Marine Management Organisation

MMO Reference: DCO/2016/00004
Planning Inspectorate Reference: EN010077

Planning Act 2008, East Anglia ONE North Limited, Proposed East Anglia ONE North Offshore Windfarm Order

Relevant Representation

Drawing file: published-documents / EN010077-001079-6.2.7.7 EA1N ES Figure 7.7 Offshore Cable Corridor and Landfall.pdf

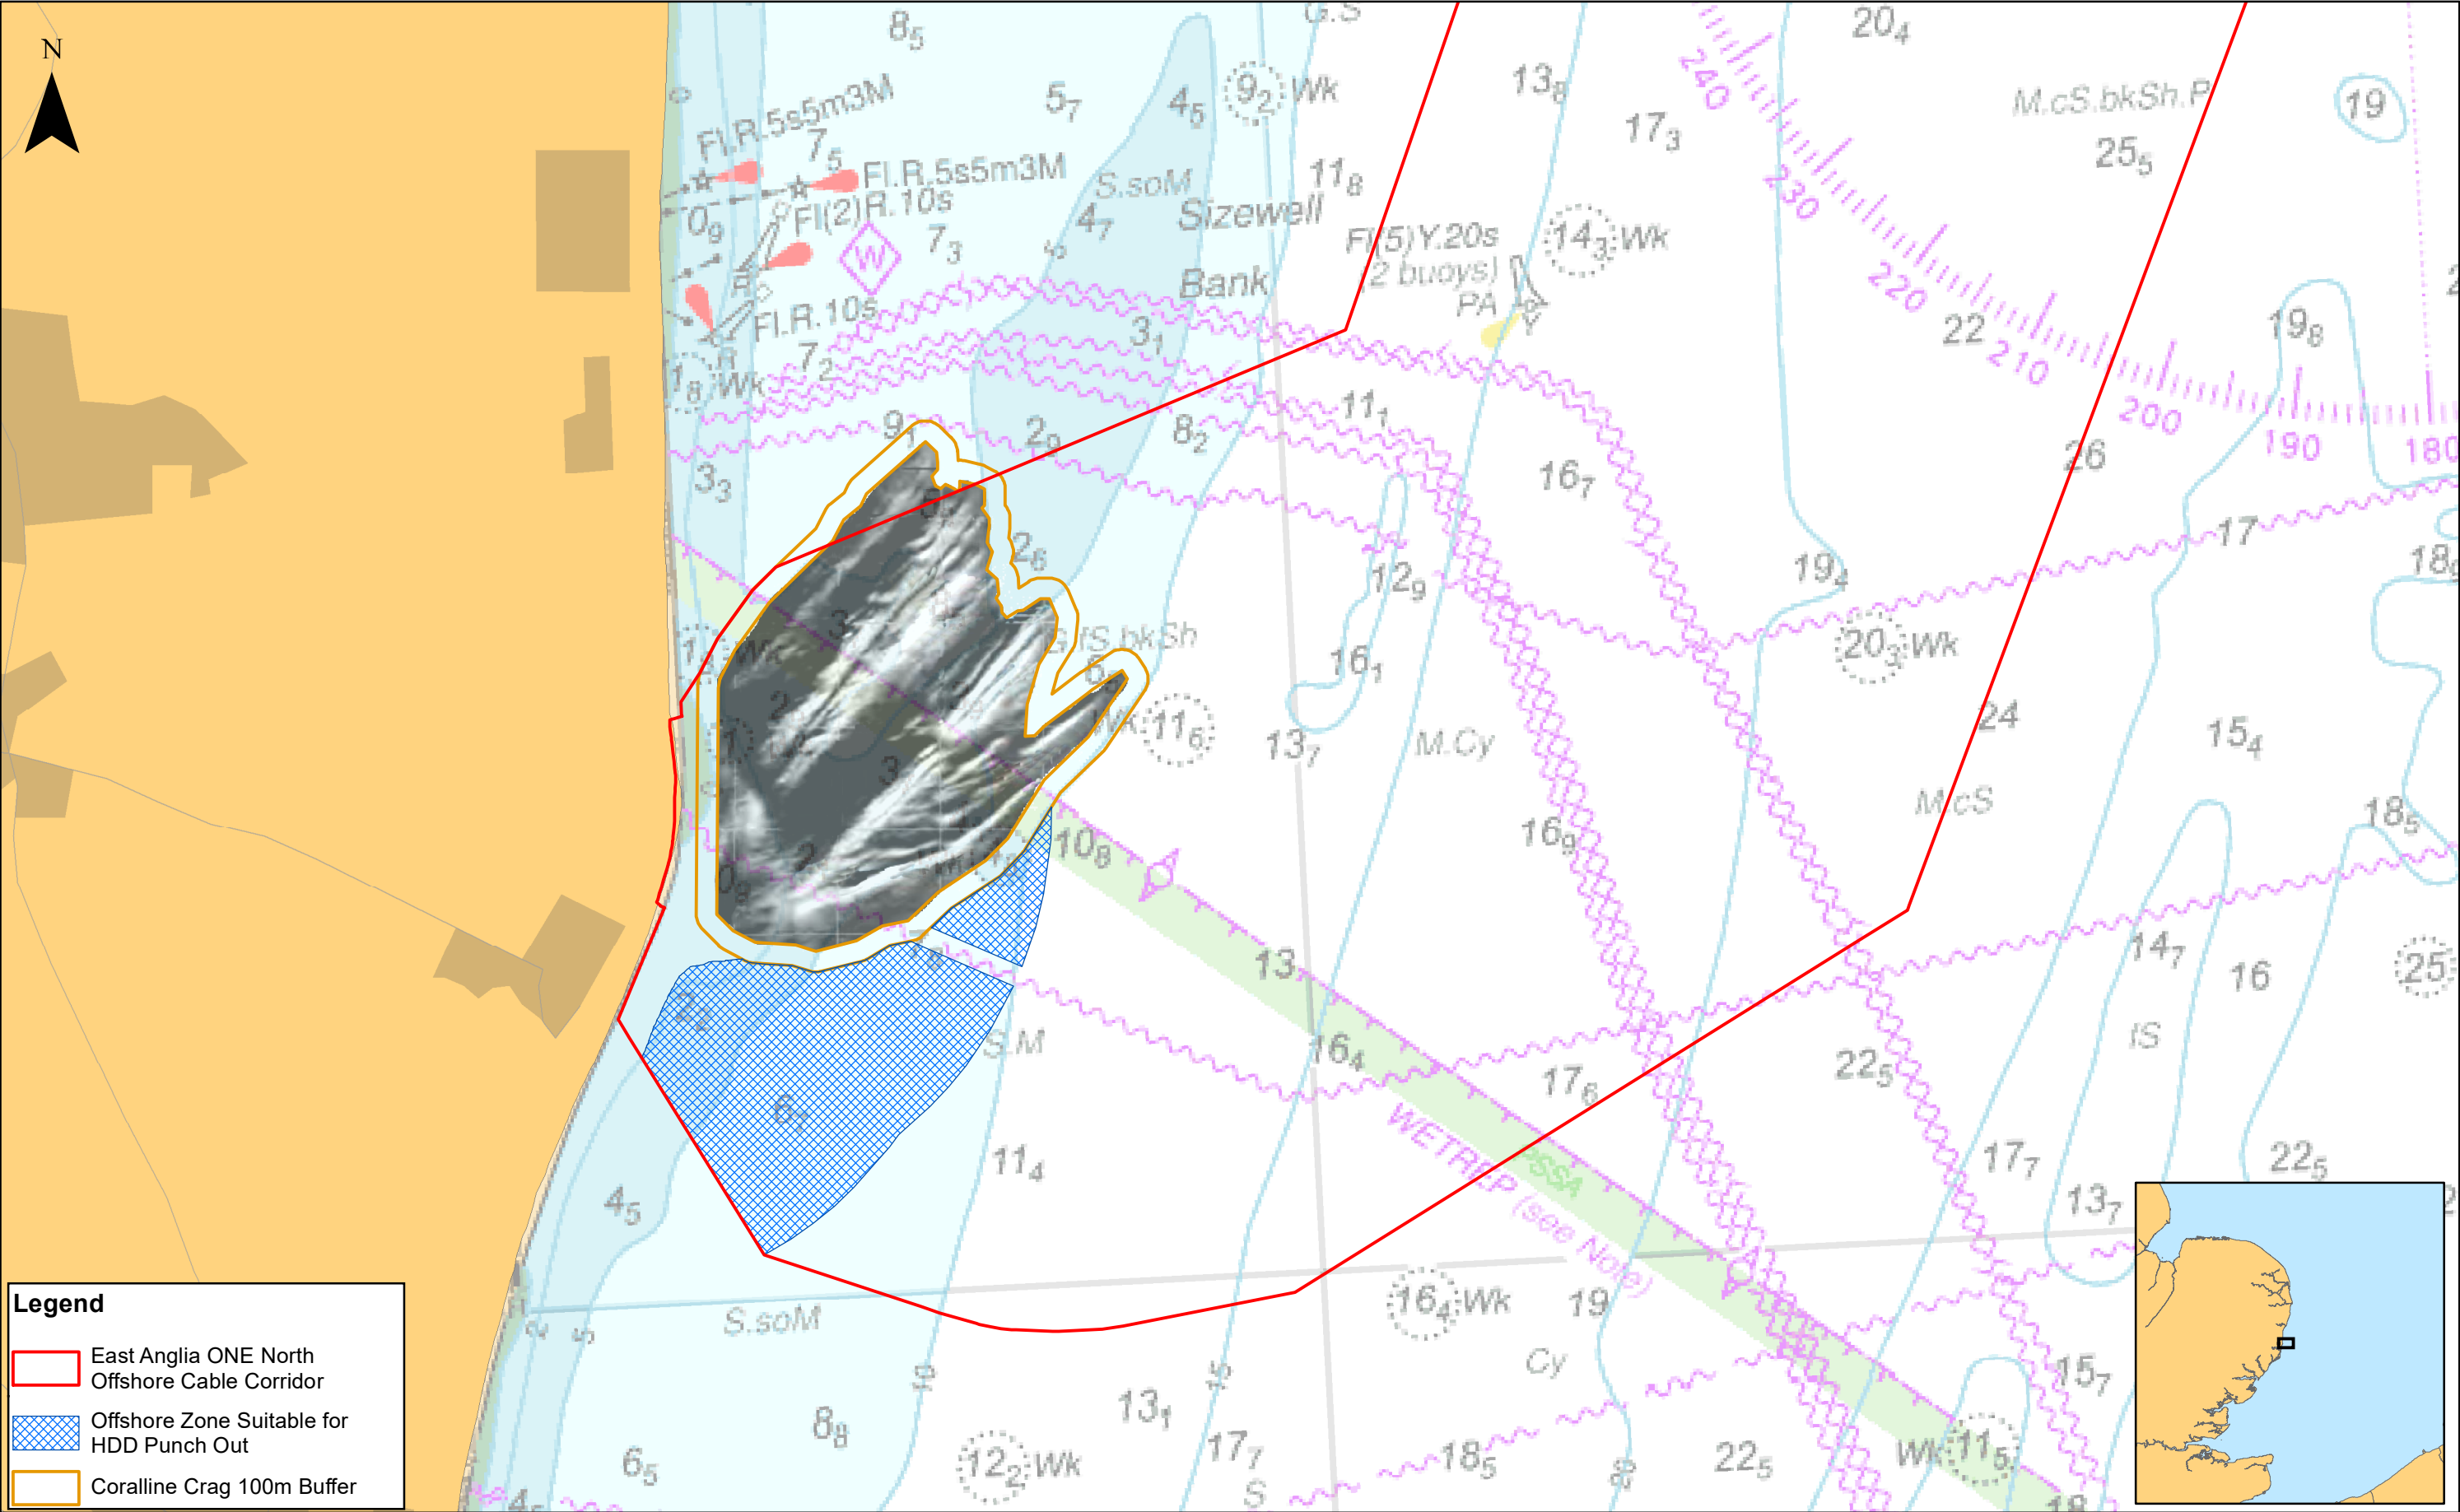
- a) Micro-siting:
 - i. e.g., See Schedule 14, Part 2, Paragraph 13.1(a) of the DML
- b) General cable burial depths:
 - i. See Schedule 14, Part 2, Paragraph 13.1(d) of the DML
- c) Landfall location:
 - i. e.g., See Schedule 14, Part 2, Paragraph 13.1(a) of the DML (as shown by the blue hatched area in Figure 7.7)
- d) Landfall cable burial:
 - i. e.g., See Schedule 14, Part 1, Paragraph 3.5(a) of the DML
- e) Foundations with greatest potential scour:
 - i. e.g., See Schedule 14, Part 2, Paragraph 13.1(d) of the DML
- f) Foundations with lesser potential scour:
 - i. e.g., See Schedule 14, Part 2, Paragraph 13.1(d) of the DML
- g) Piled foundation types:
 - i. e.g., See Schedule 14, Part 2, Paragraph 13.1(d) of the DML
